**Subject:** 2026/90343 at location 54, Victoria Street, Clayton West, Huddersfield, HD8 9NW

Please see ecological commentary below:

**Pre-Development Plan
Baseline Map**

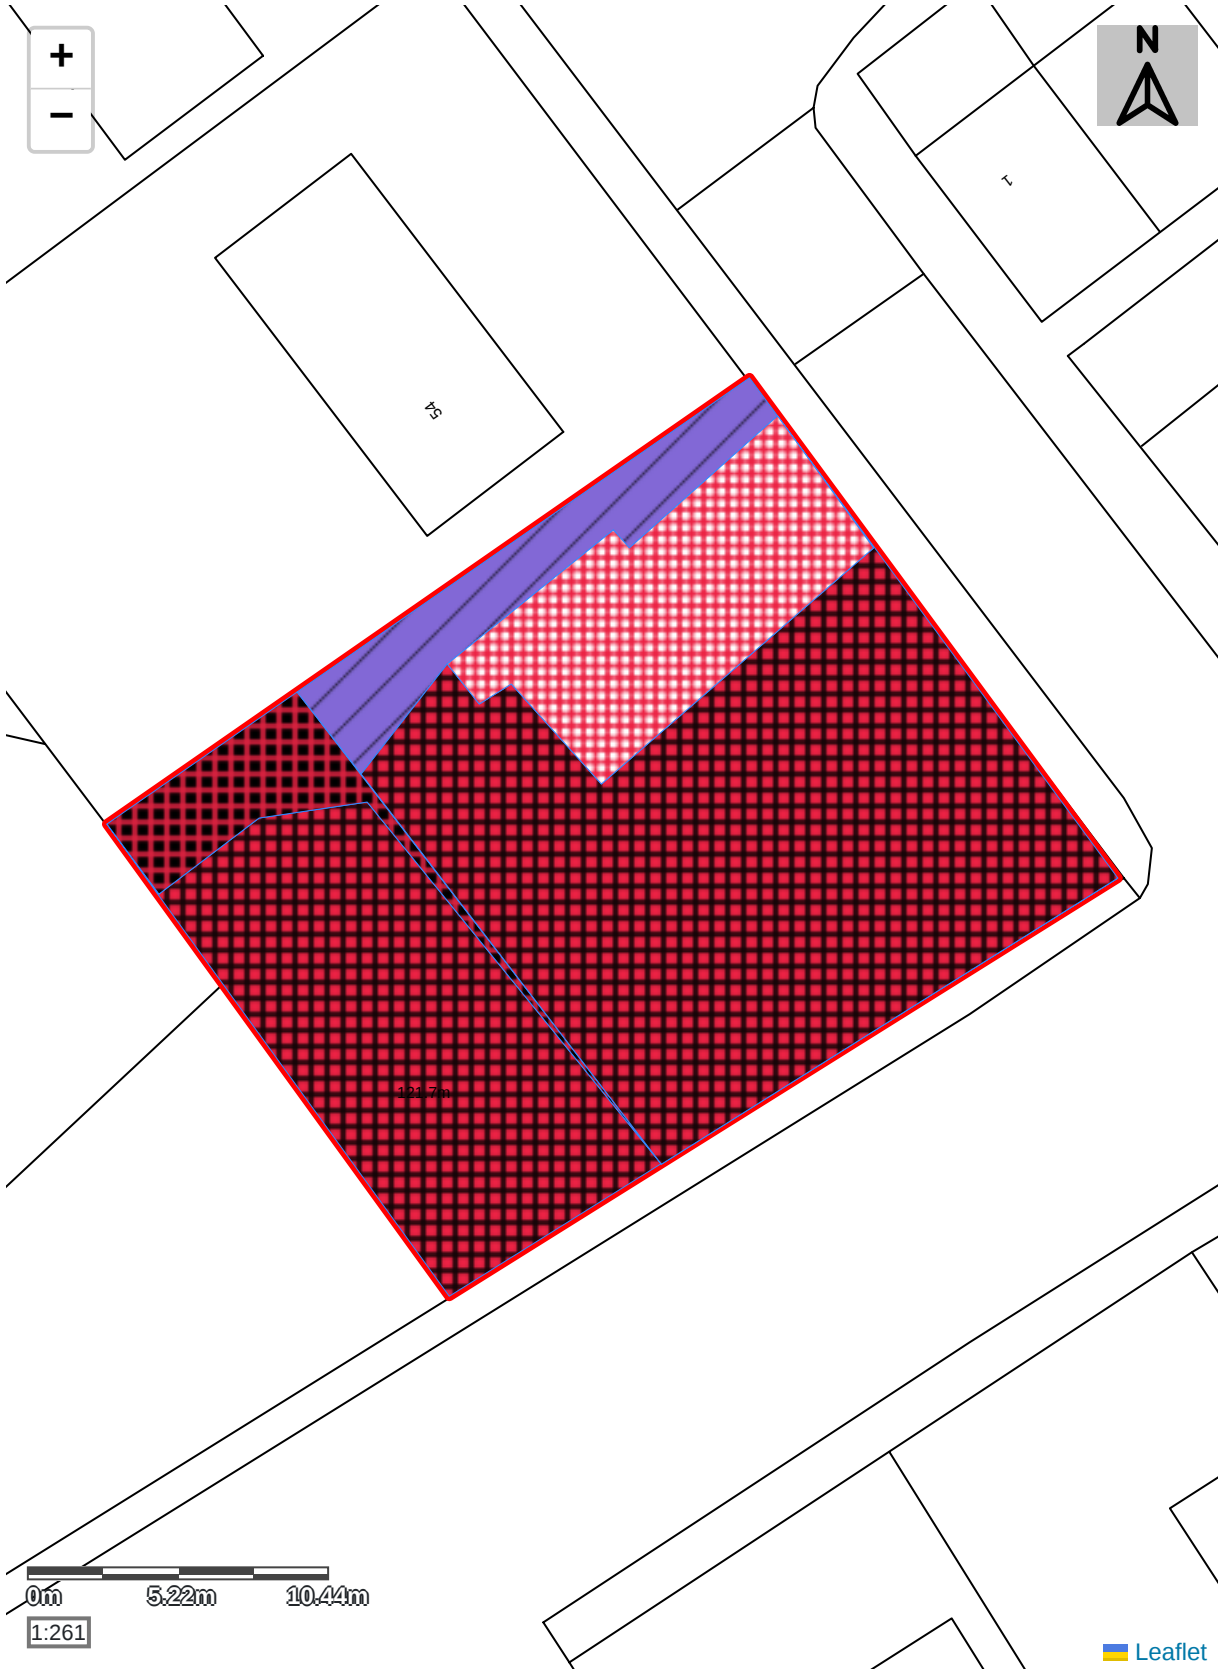
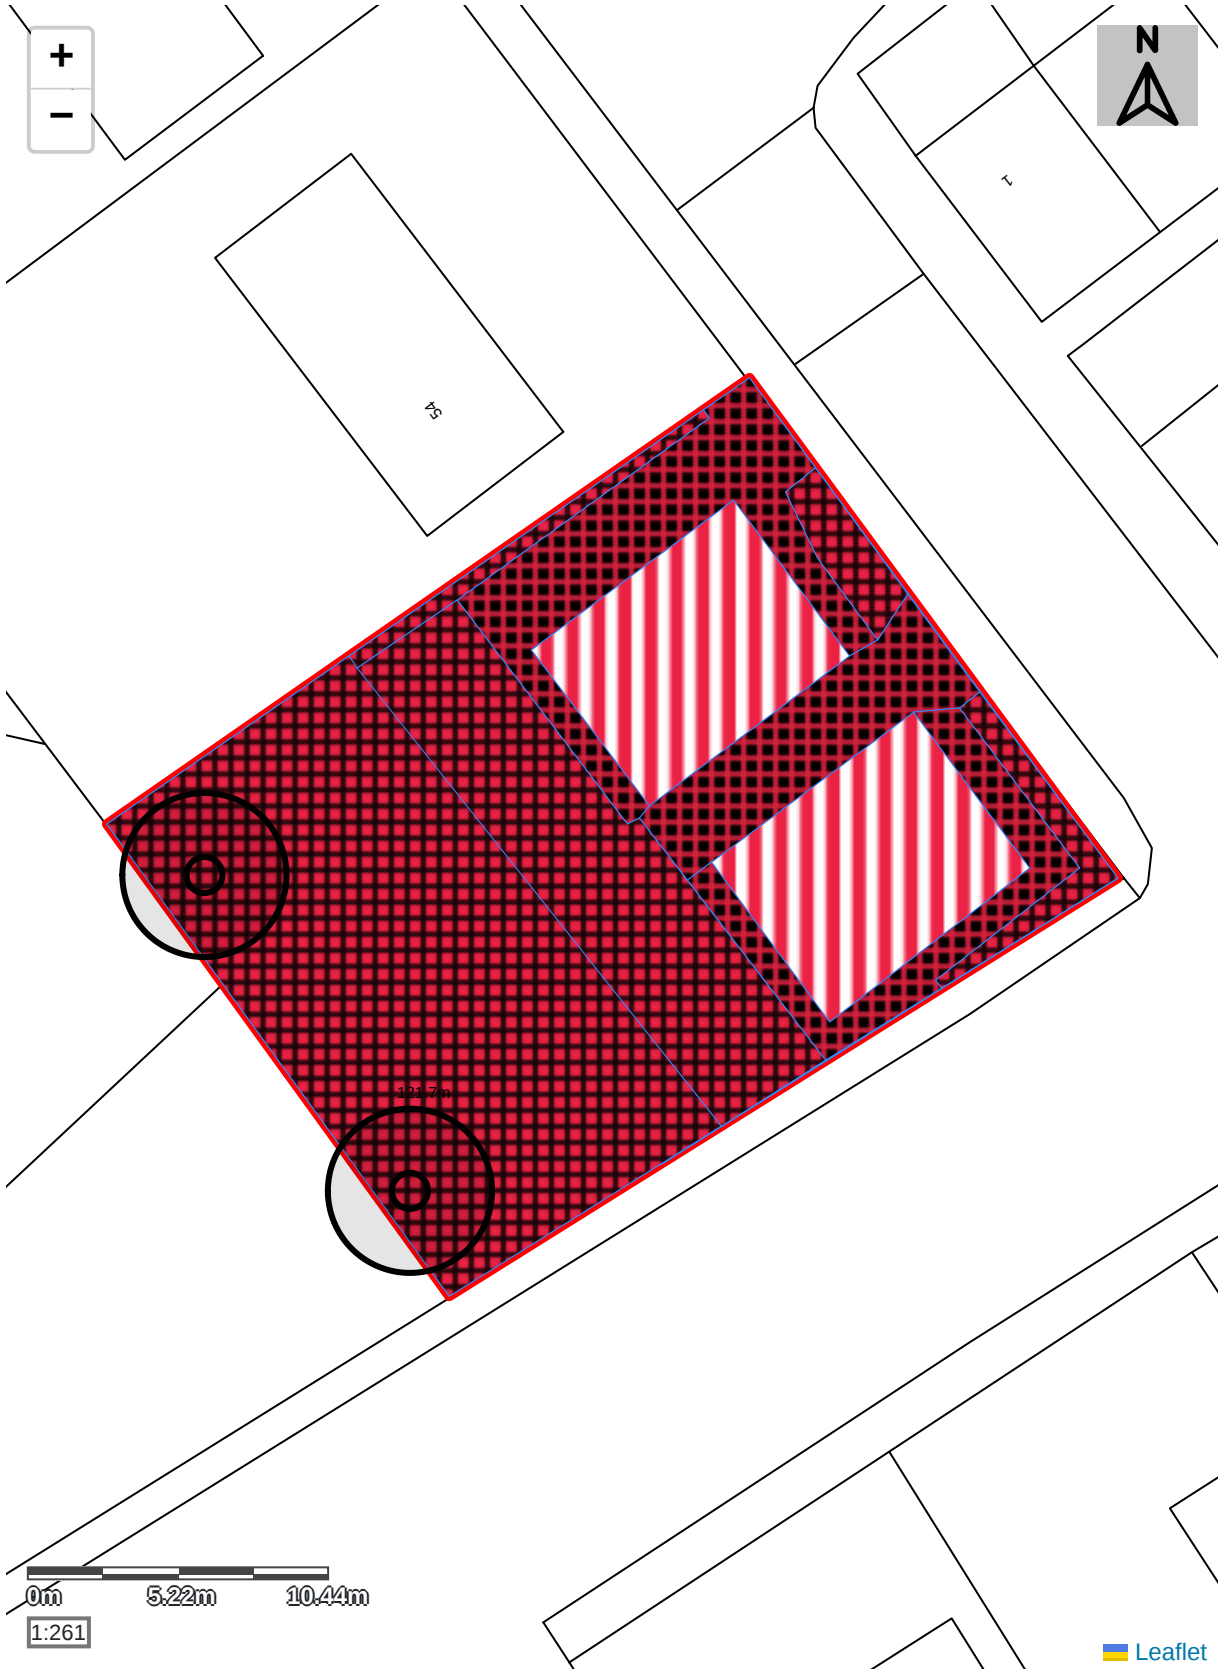
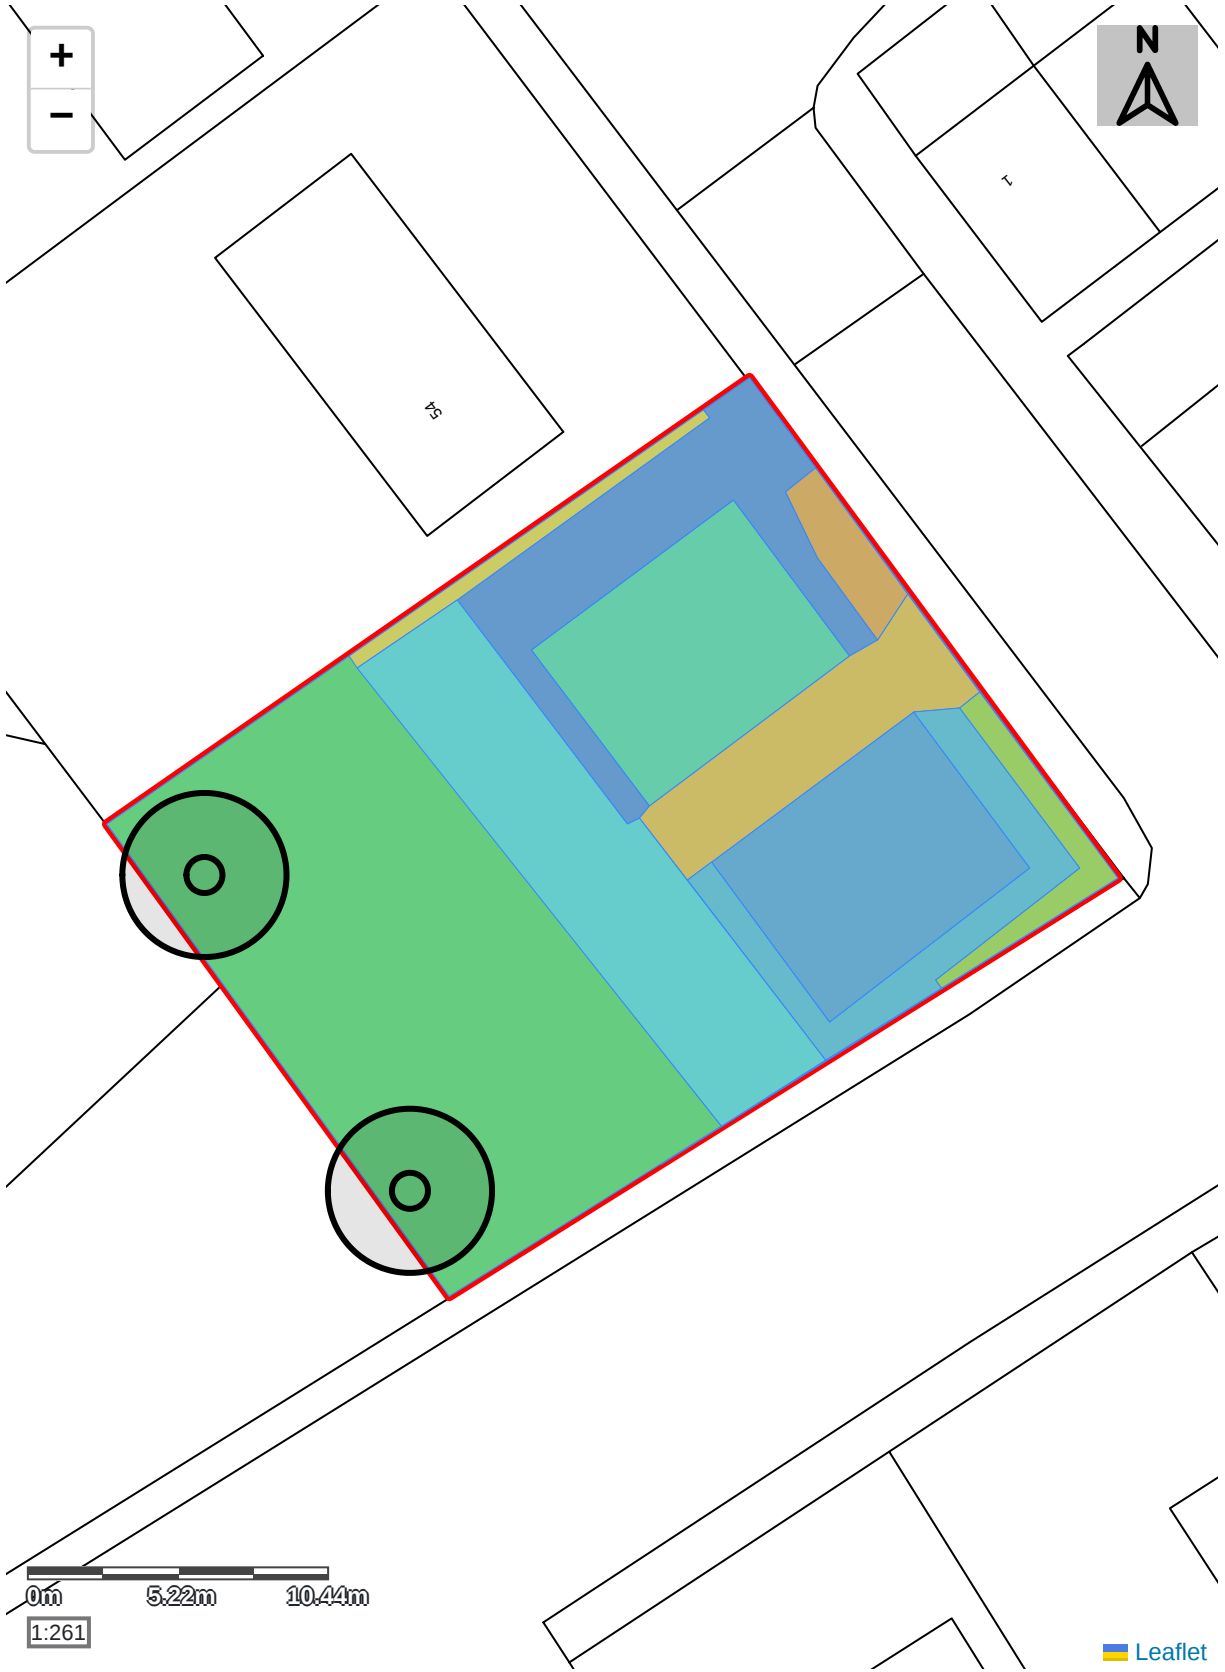
- The trees mentioned in the PEA report are not mentioned in the “Baseline habitats” of tab “5. Area habitats” of the metric.
- The metric is missing “mixed native shrub” as mentioned in the PEA.
- The wall (built linear feature) is also not mentioned.

The baseline calcs are not validated.

PROPOSED HOUSING DEVELOPMENT
54 VICTORIA STREET, CLAYTON WEST, HD8 9NW
DWG No. 682-A12 rev--
SCALE 1:200@A3 NOVEMBER 2025

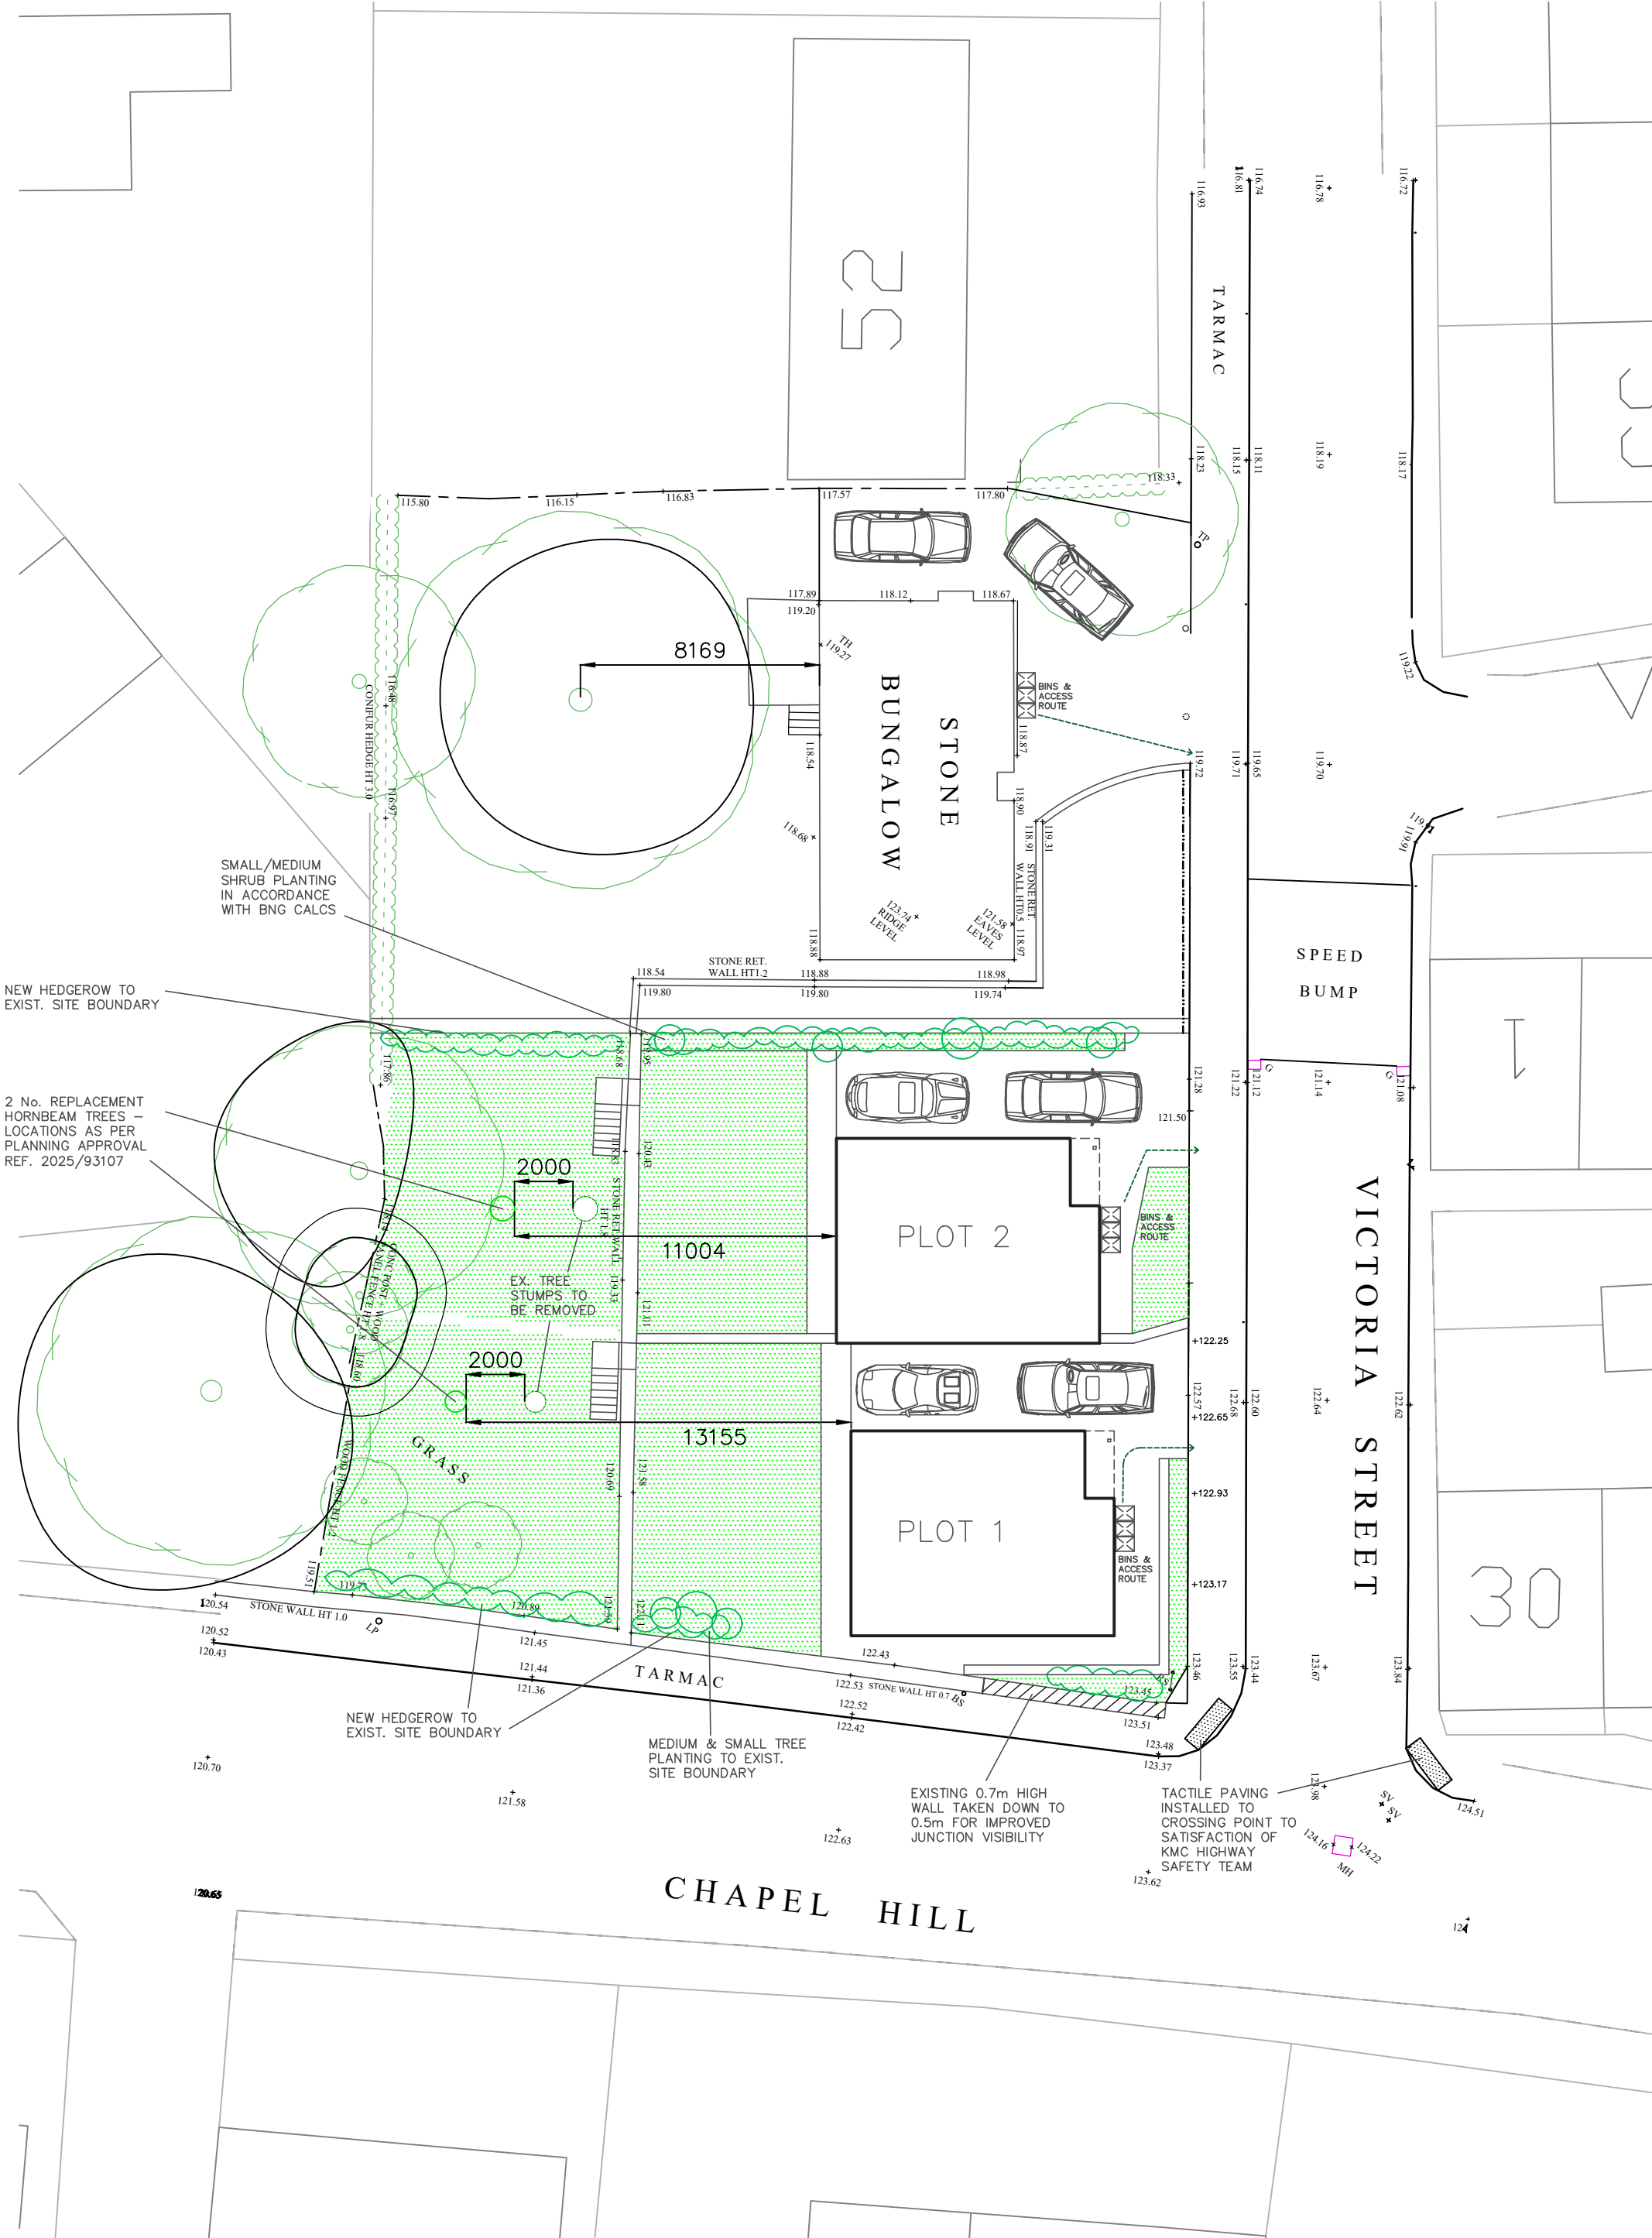
- 2no large trees are mentioned to be planted / created as part of post-development habitats  
The Small Sites Metric User guide states that “When planting trees post-development size class is determined by the size of the tree at site-planting.” The natural size increases of planted trees within post-development calculations must not be recorded. Newly planted individual trees must be recorded as “Small” at the time of planting unless tree translocation is taking place. No management plans indicate that large tree translocation is taking place. As such, a revised metric where the trading rules are met and the Number of New Trees Planted Post-Development column within 1d. – Tree area calculator uses the Small categorisation for trees is required prior to decision.

- Also, the 2no large trees to be planted will have a canopy that will result in 1,530m<sup>2</sup>, while the site is mentioned to be 561.64m<sup>2</sup>, which would not be possible. This is not in line with metric principles 7 and 9 of the BNG requirements.
